Our ref: DOC19/1017918-8

Your ref: SSI 8896

Belmont drought response desalination plant – Environmental Impact Statement

I refer to your email dated 21 November 2019 seeking Biodiversity and Conservation Division (BCD) comment on the Belmont drought response desalination plant proposal located in Belmont South within the Lake Macquarie City Council area.

Coastal Erosion and Recession Risk
for 2010, 2050 and 2100

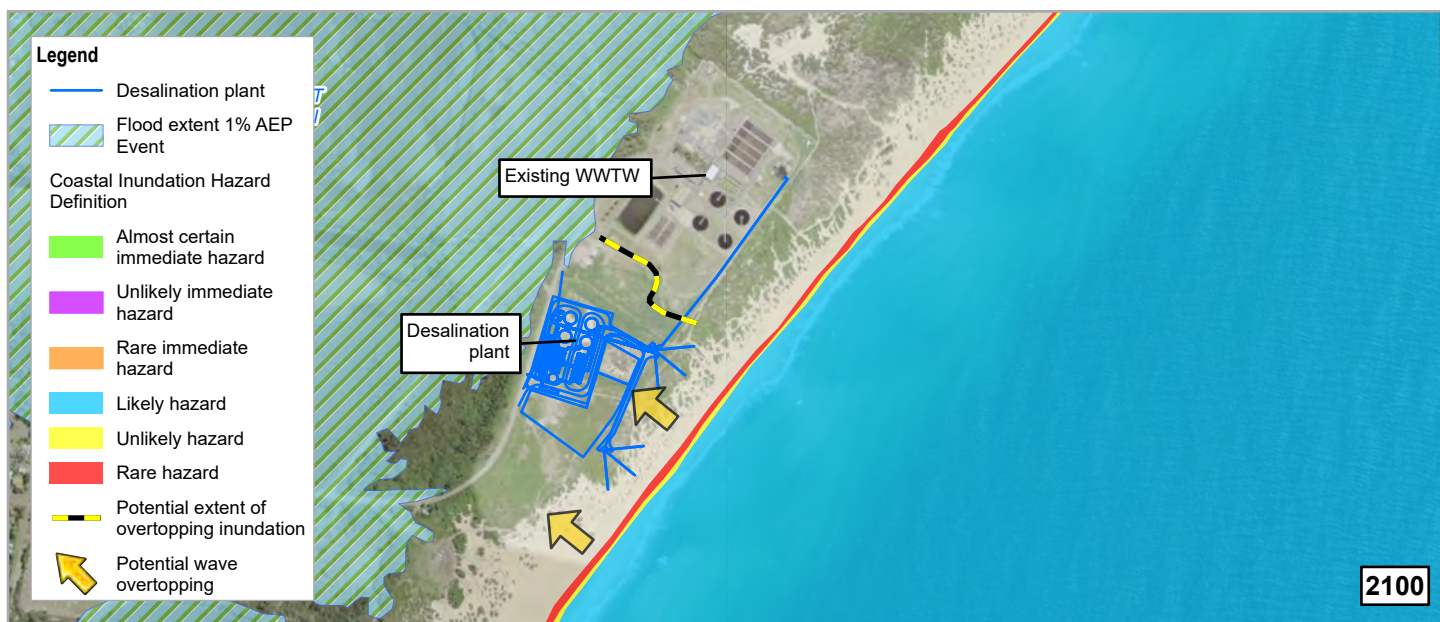
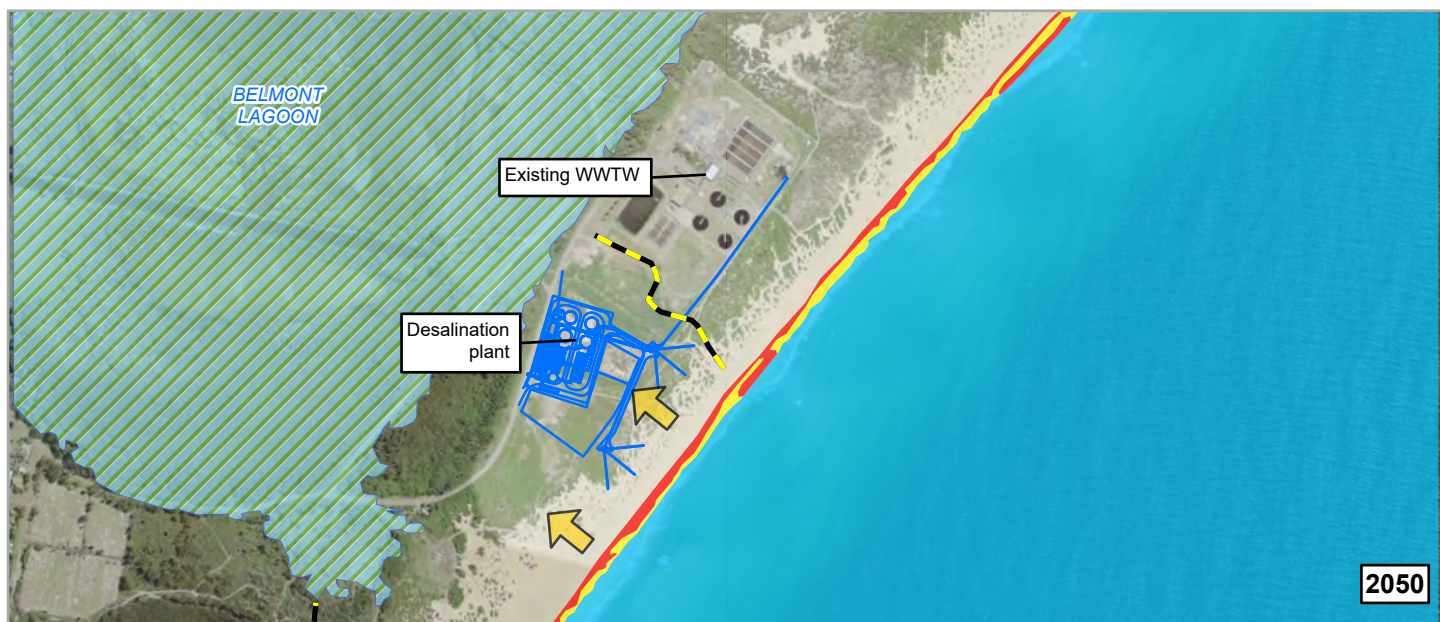
The EIS identifies coastal erosion and recession risks to the proposed seawater intake structures. To ensure the risk of damage to these structures from coastal erosion and sea level rise is minimised, further investigations should be undertaken during detailed design into locating the intake cassions further landward with longer horizontal intake pipes.

Further investigations should be undertaken during detailed design into locating the intake cassions further landward with longer horizontal intake pipes.
